# CITY OF ALBUQUERQUE

October 30, 2018

**Re: Arroyo Vista Apartments, Phase 6. (Final)**  
**4201 Bryn Mawr 87107**  
**Request for Certificate of Occupancy**  
**Transportation Development Final Inspection**  
Engineer's/Architect's Stamp dated 11-4-16 (G16D153)  
Certification dated 10-26-18

sheet no: TCLI

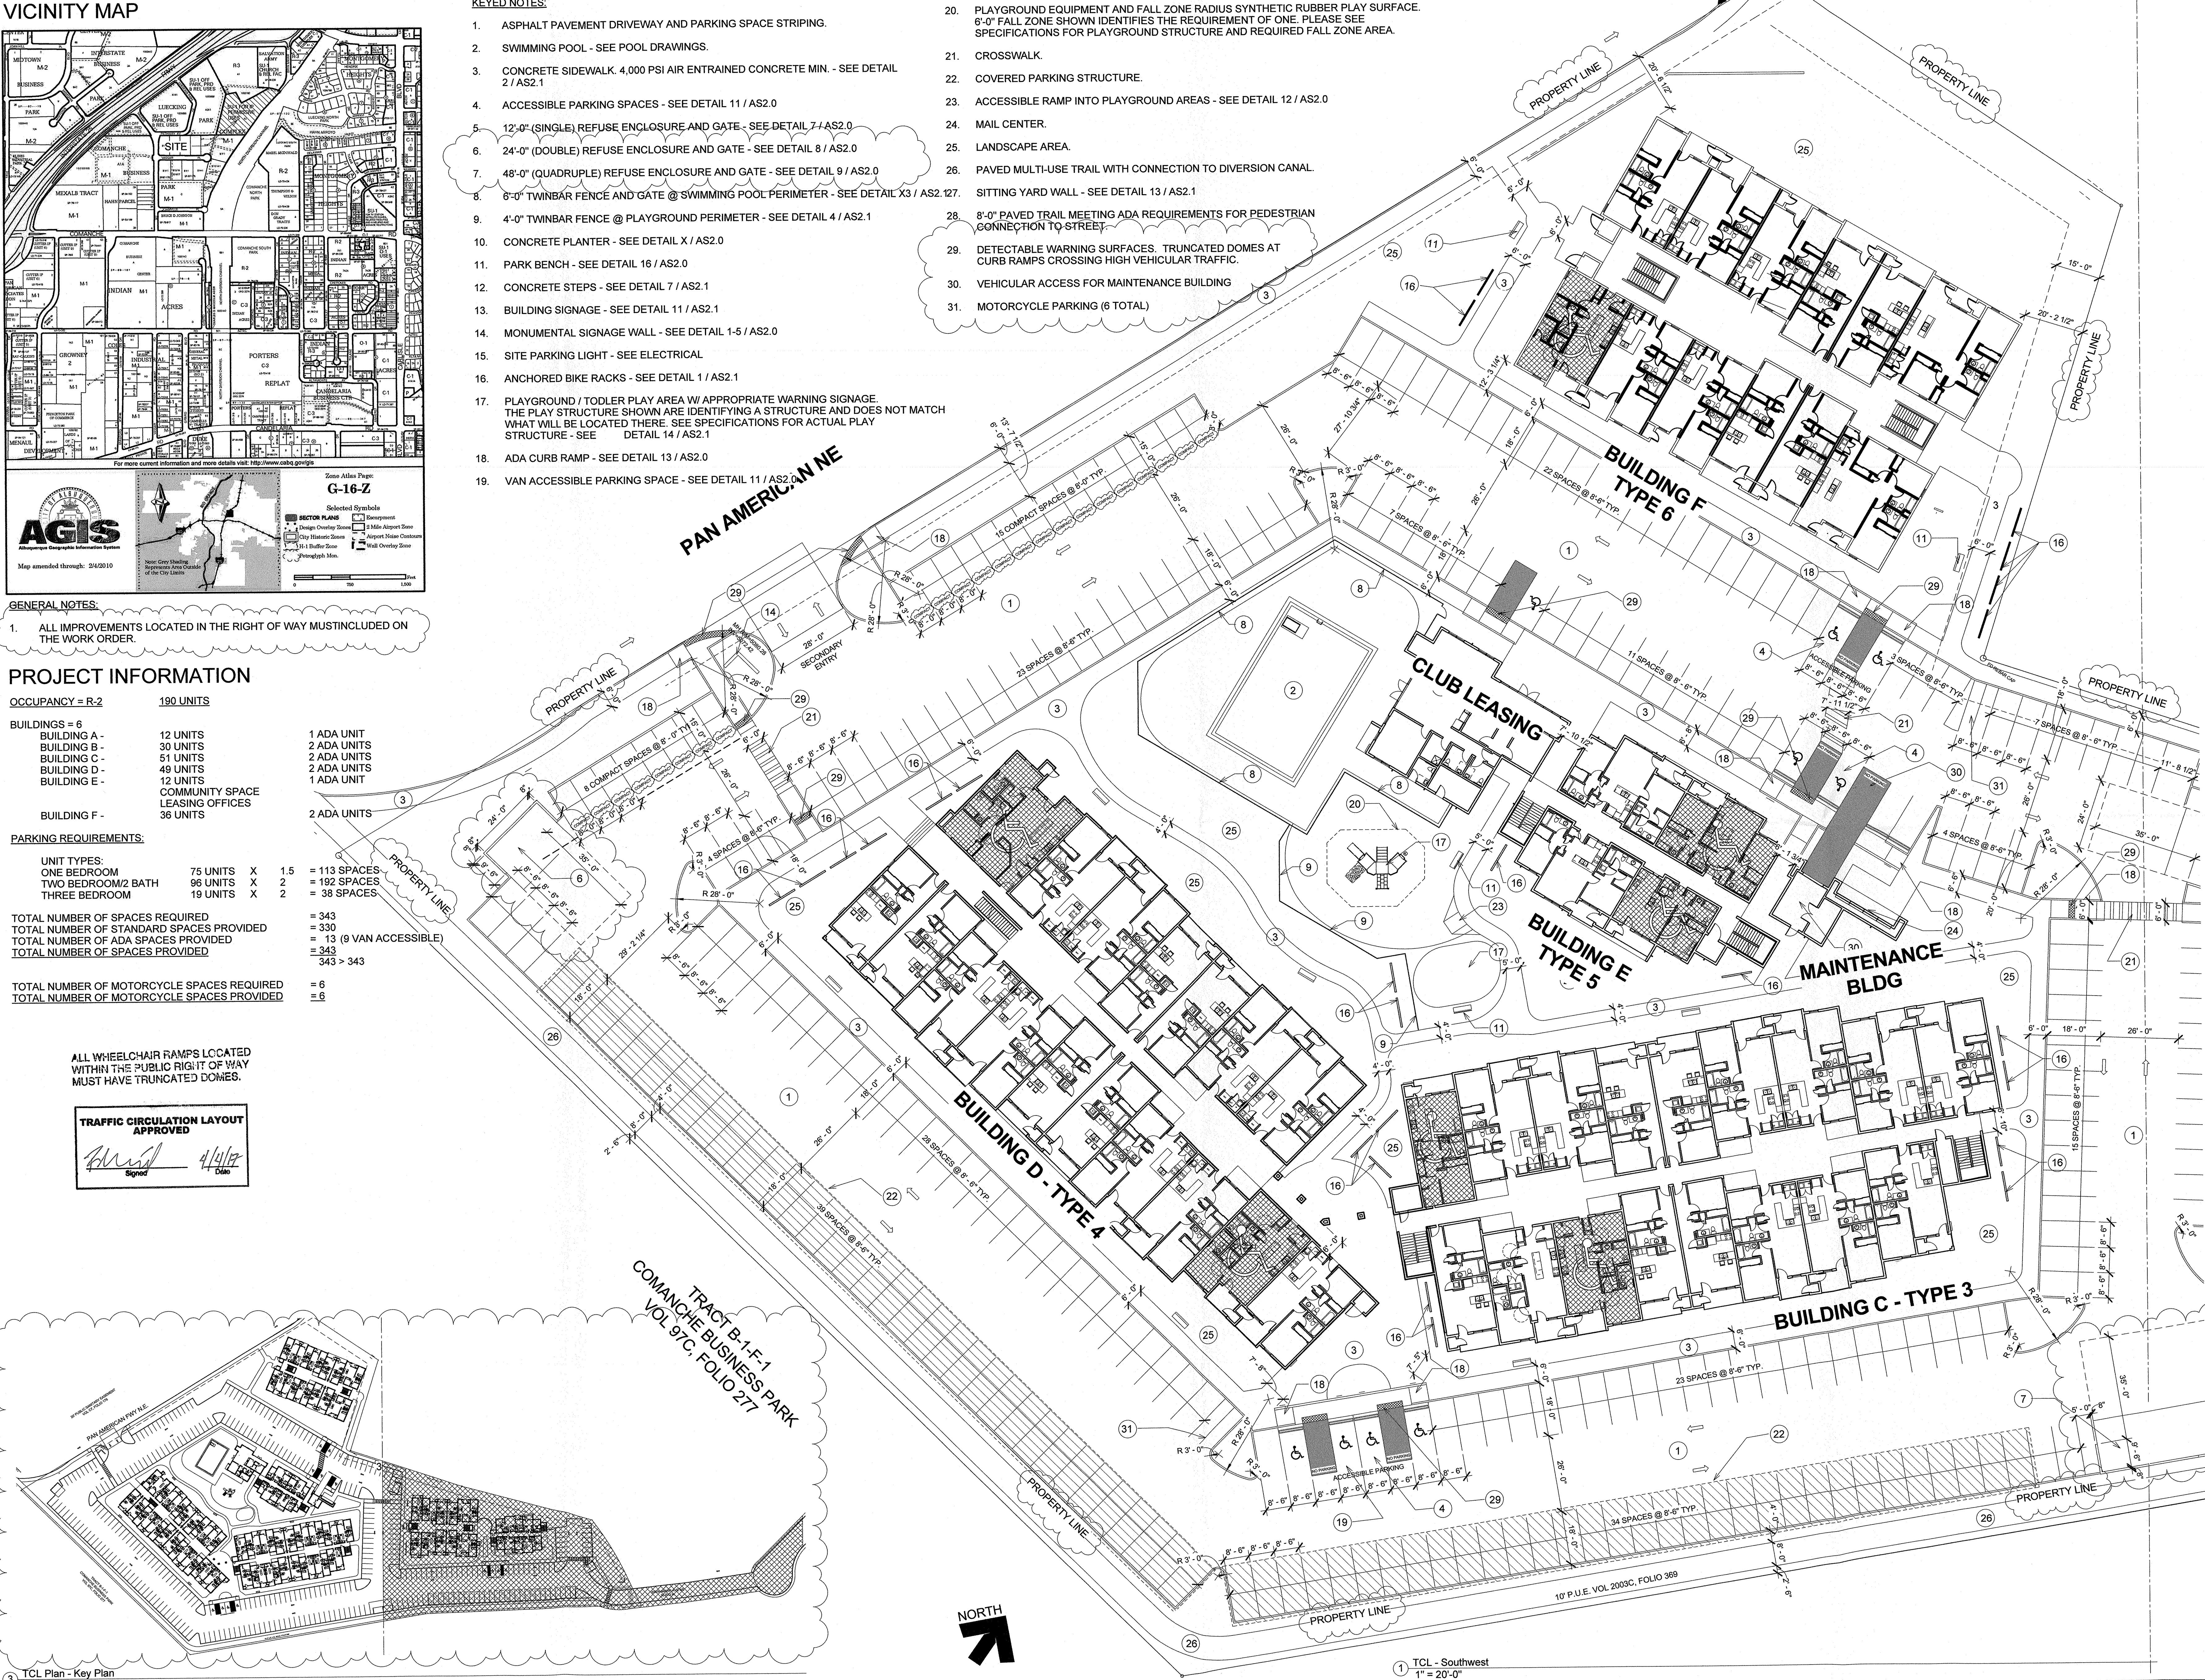
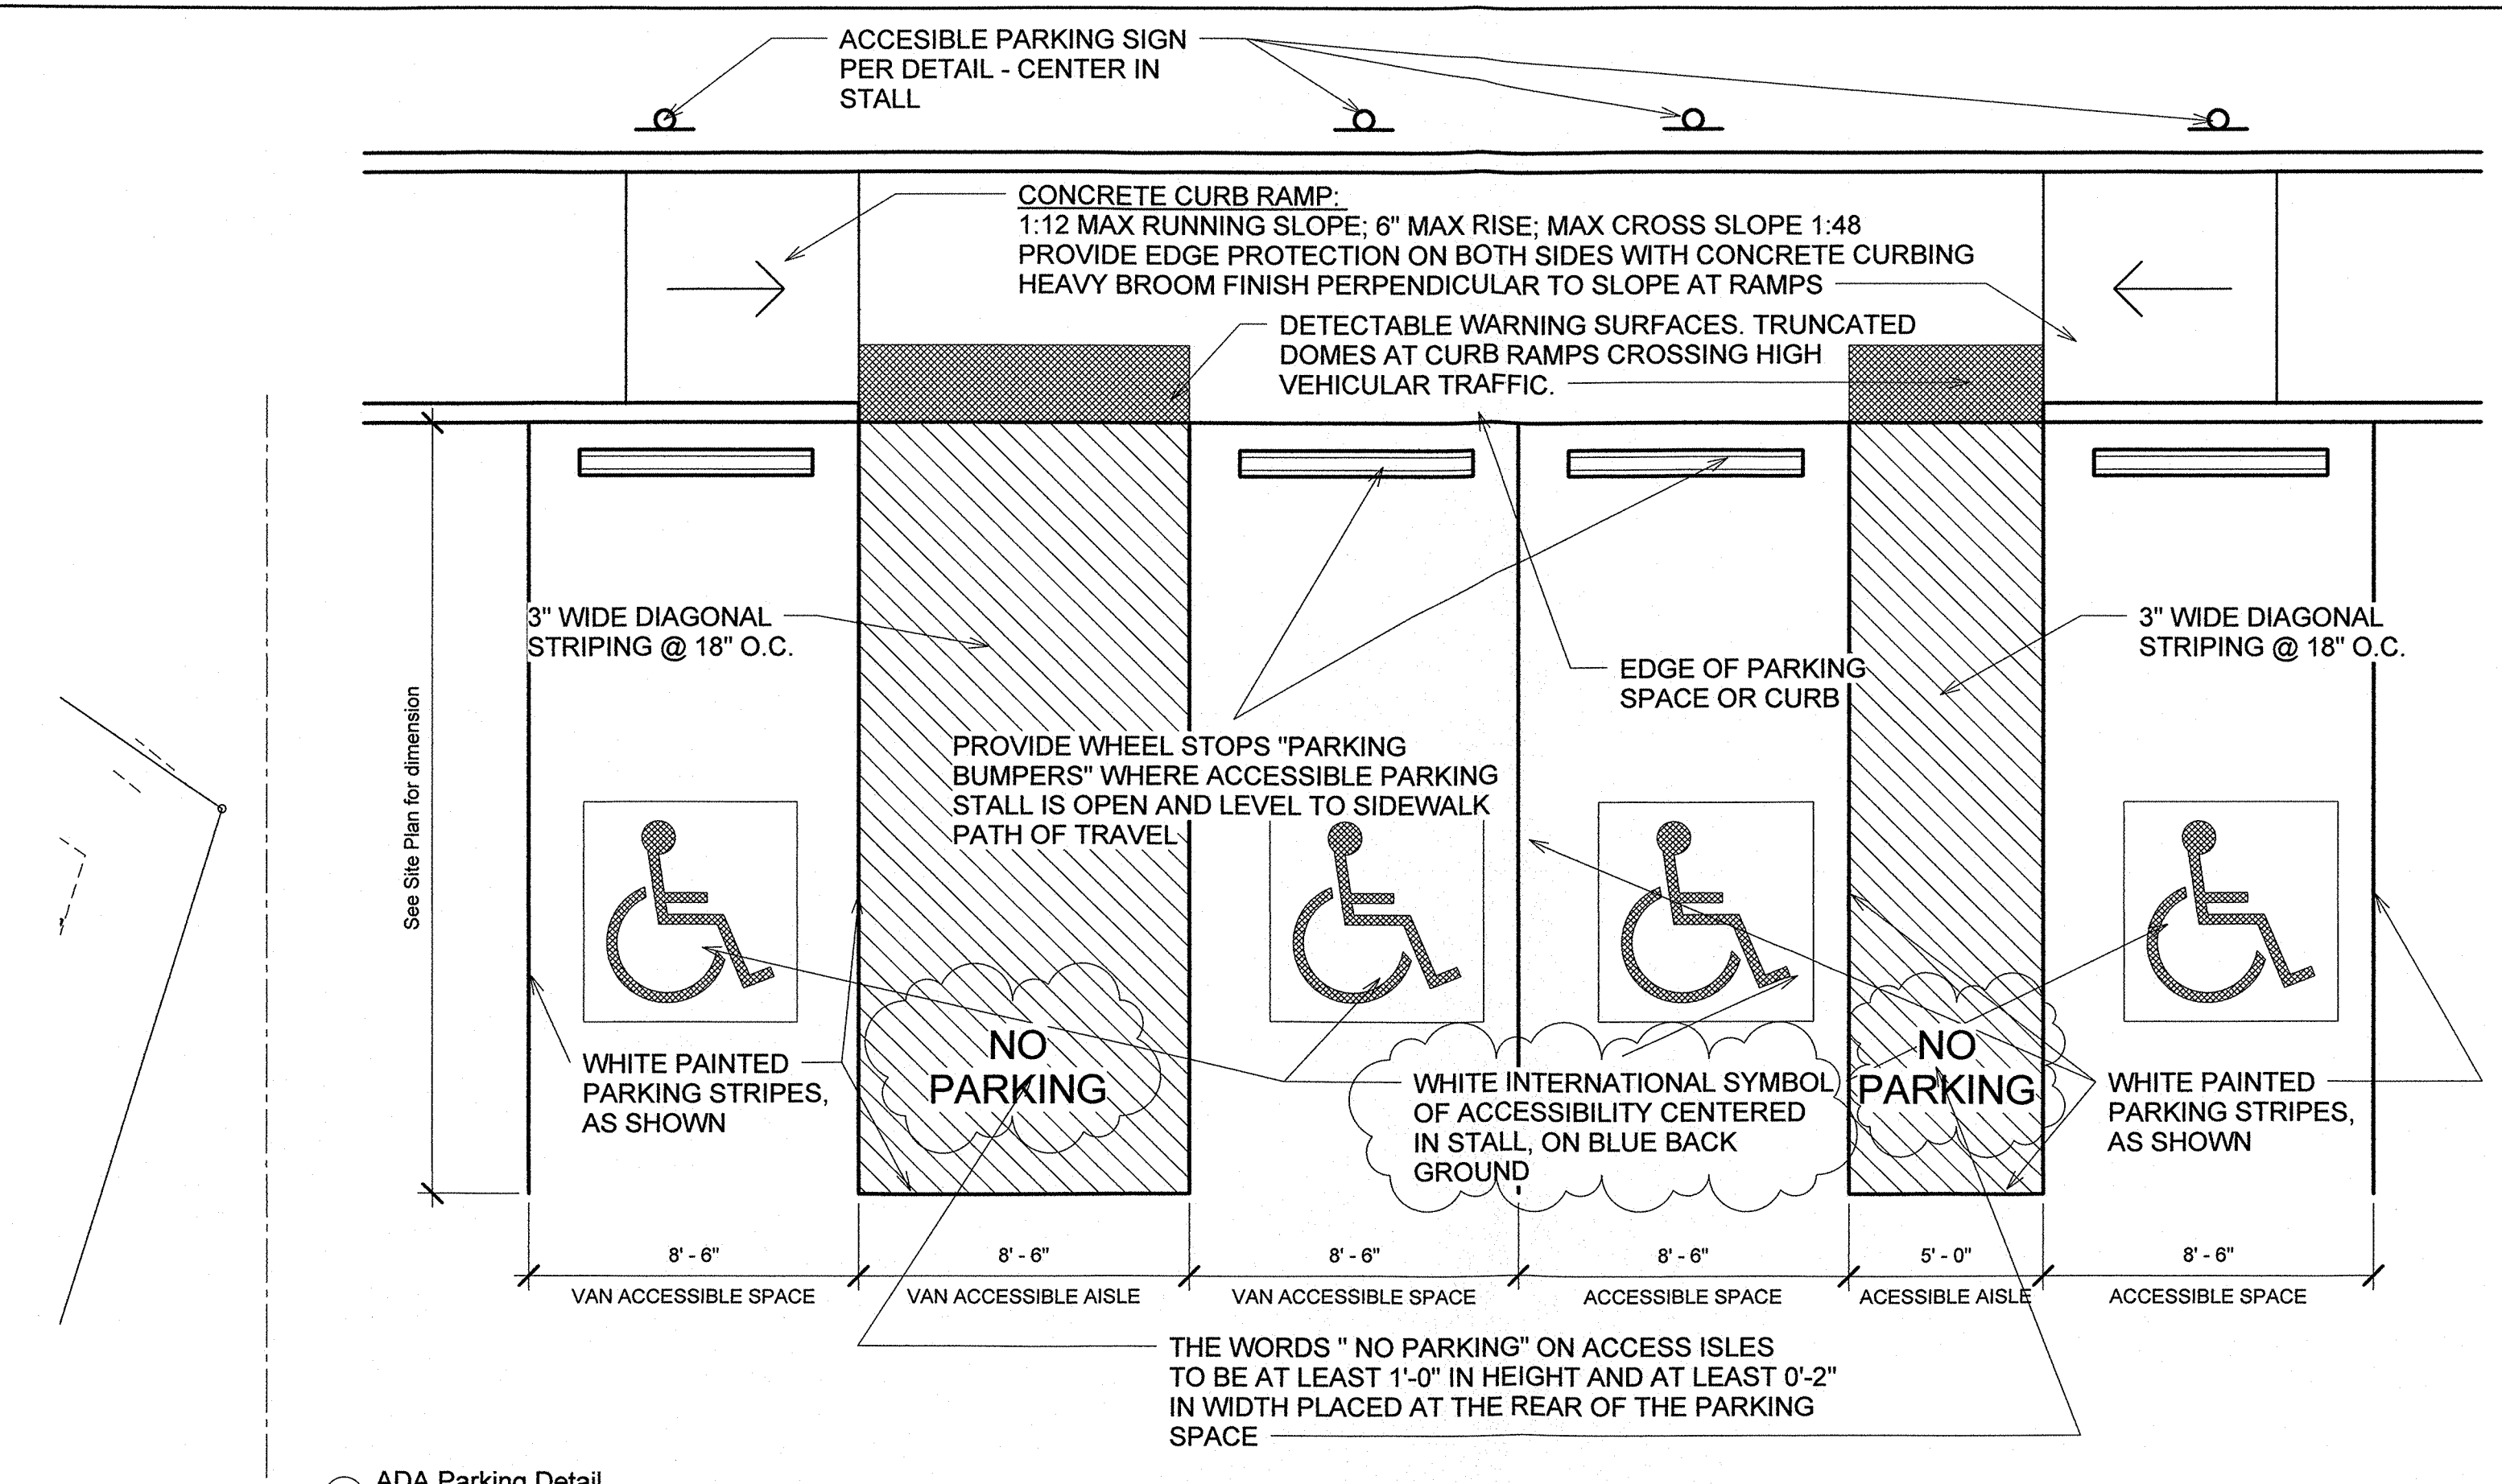
1. Please add missing truncated domes per approved TCL plan.
2. Please complete curb where canopy is being constructed over parking stalls. (Entrance of complex off Bryn Mawr).
3. The Work Order Infrastructure Must be closed out and accepted by the City of Albuquerque.
